OWL MARKETPLACE FILING NO. 1
EL PASO COUNTY, COLORADO
PRE-SUBDIVISION CIVIL CONSTRUCTION PLANS

ENGINEERING RECORD DRAWINGS
KATE VARNUM, P.E.
5/15/2026

PRE-SUBDIVISION CONSTRUCTION PLANS FOR:

OWL
MARKETPLACE
EL PASO COUNTY, COLORADO

10'X6' CULVERT INLET
SCALE: 1"=10'

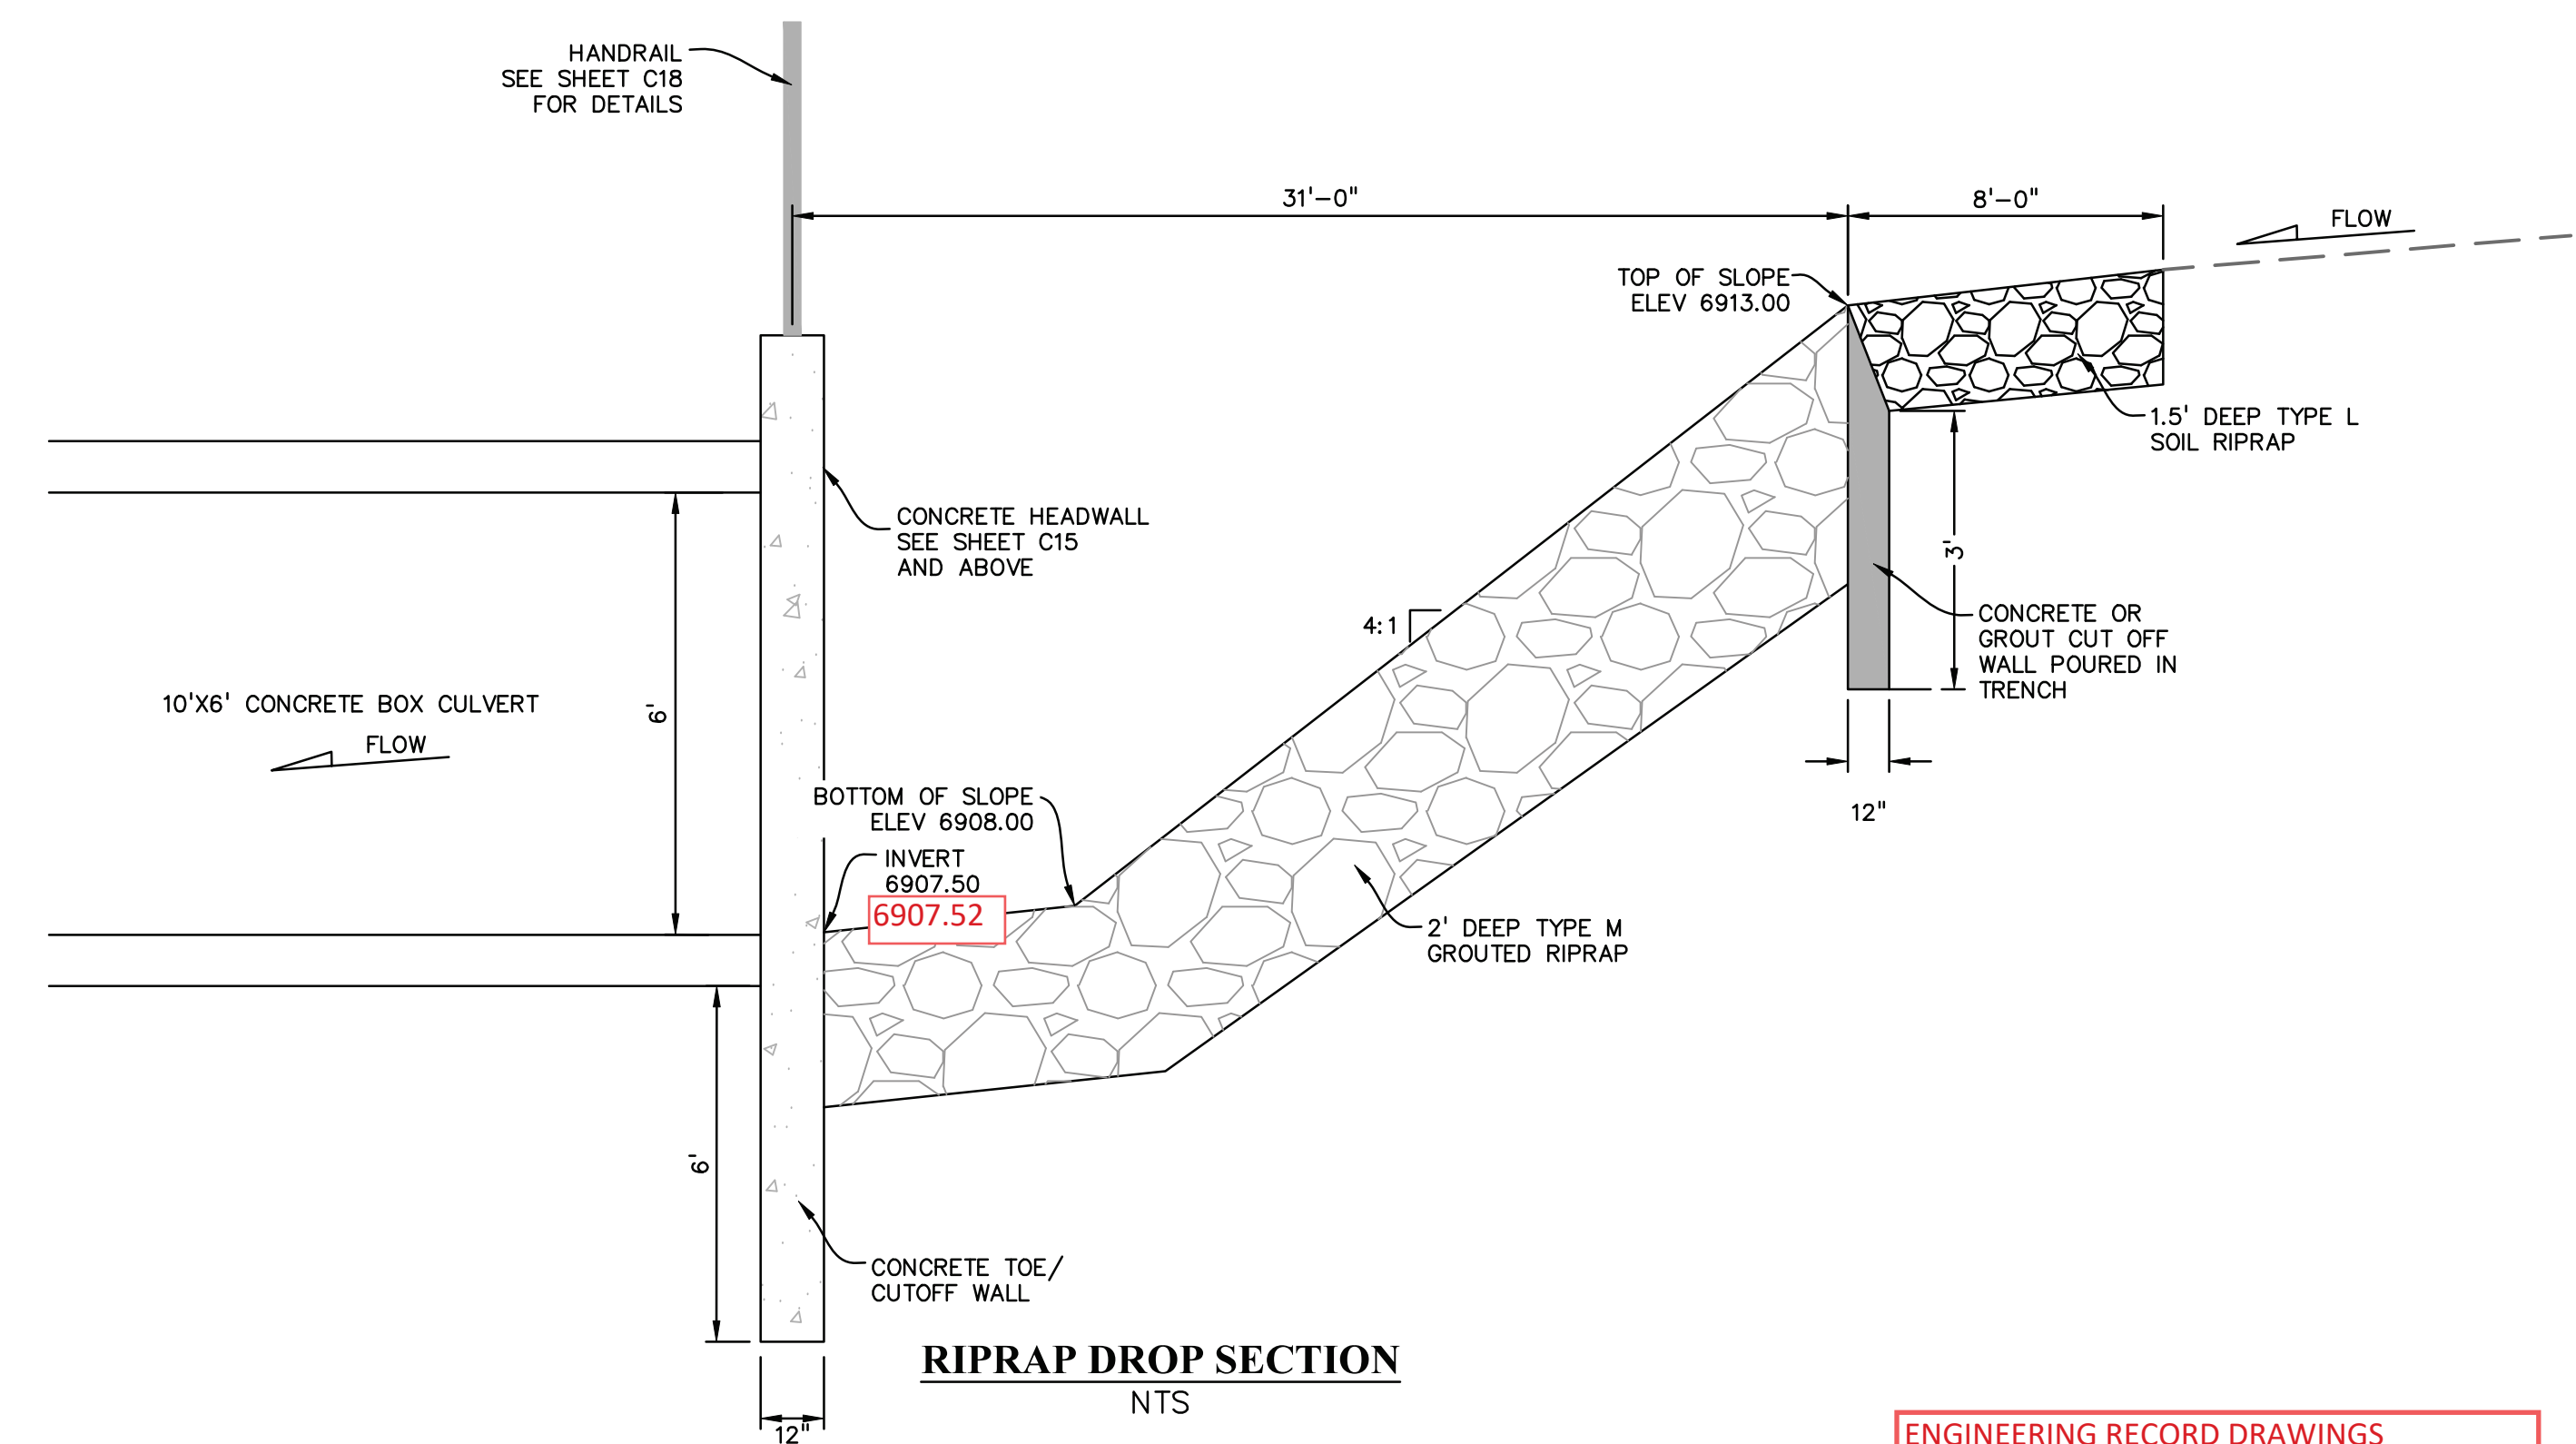
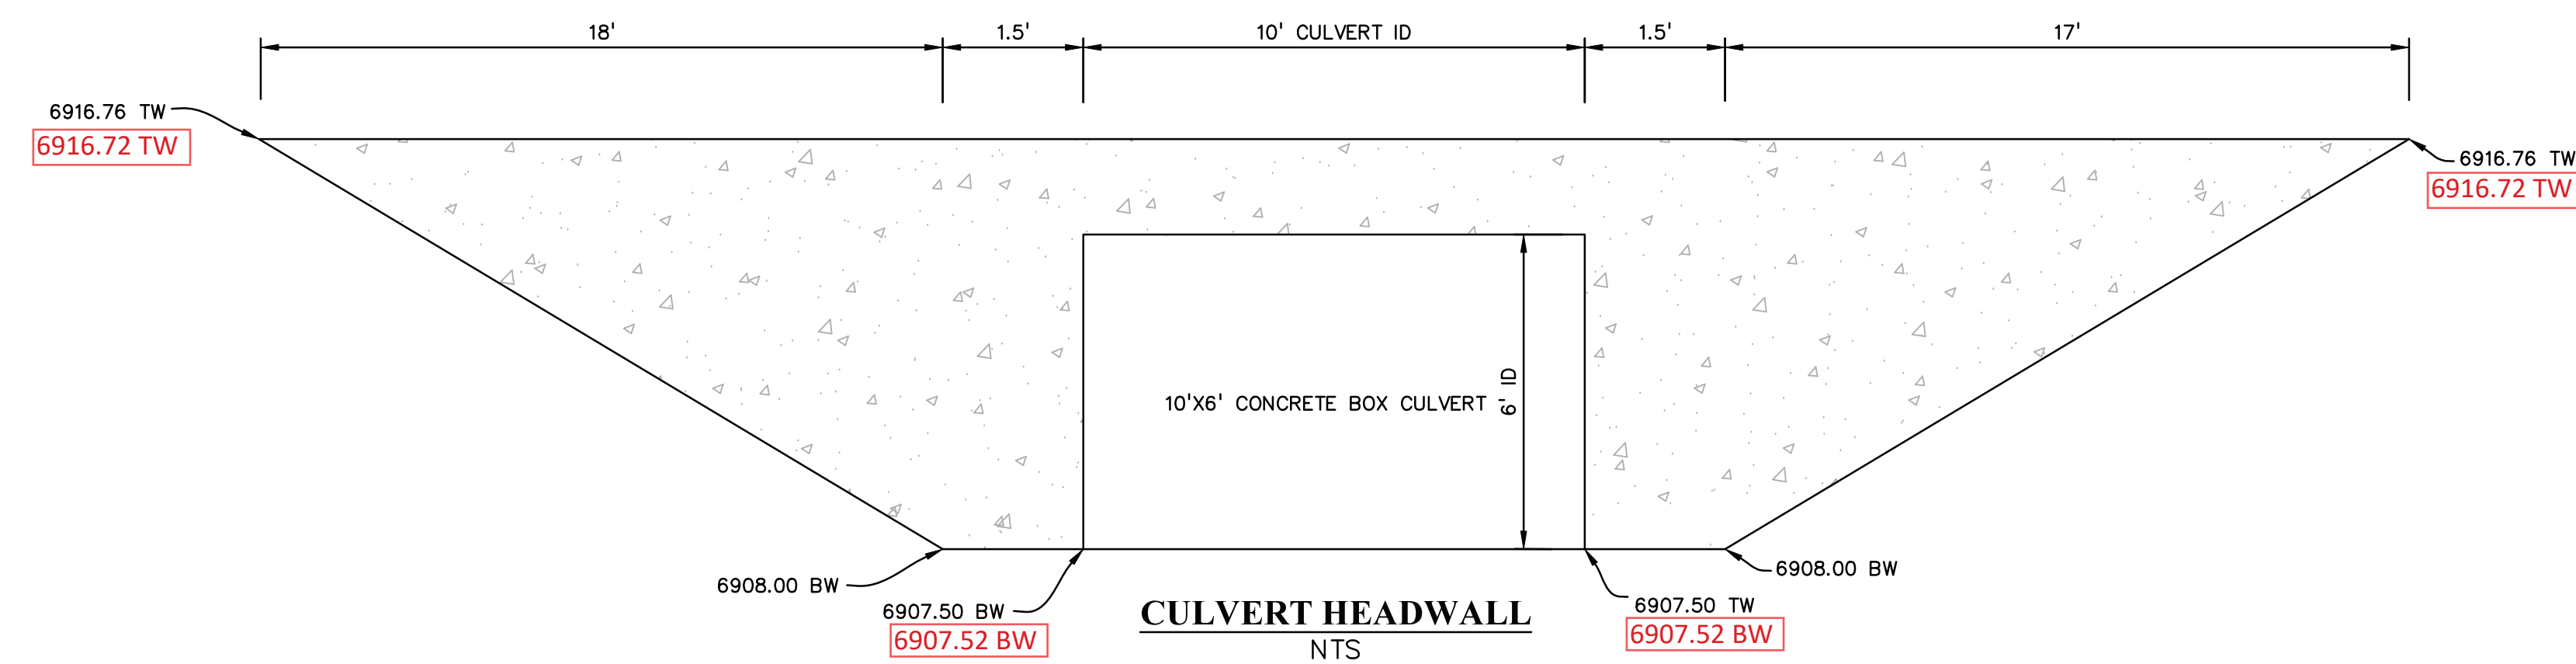
As of our PA walk in April, this was installed as plain riprap, not soil riprap. Please check with the contractor/developer and then as-built this accordingly (with calcs to show that plain riprap works) or install per plans in the field. April photo provided below for reference:
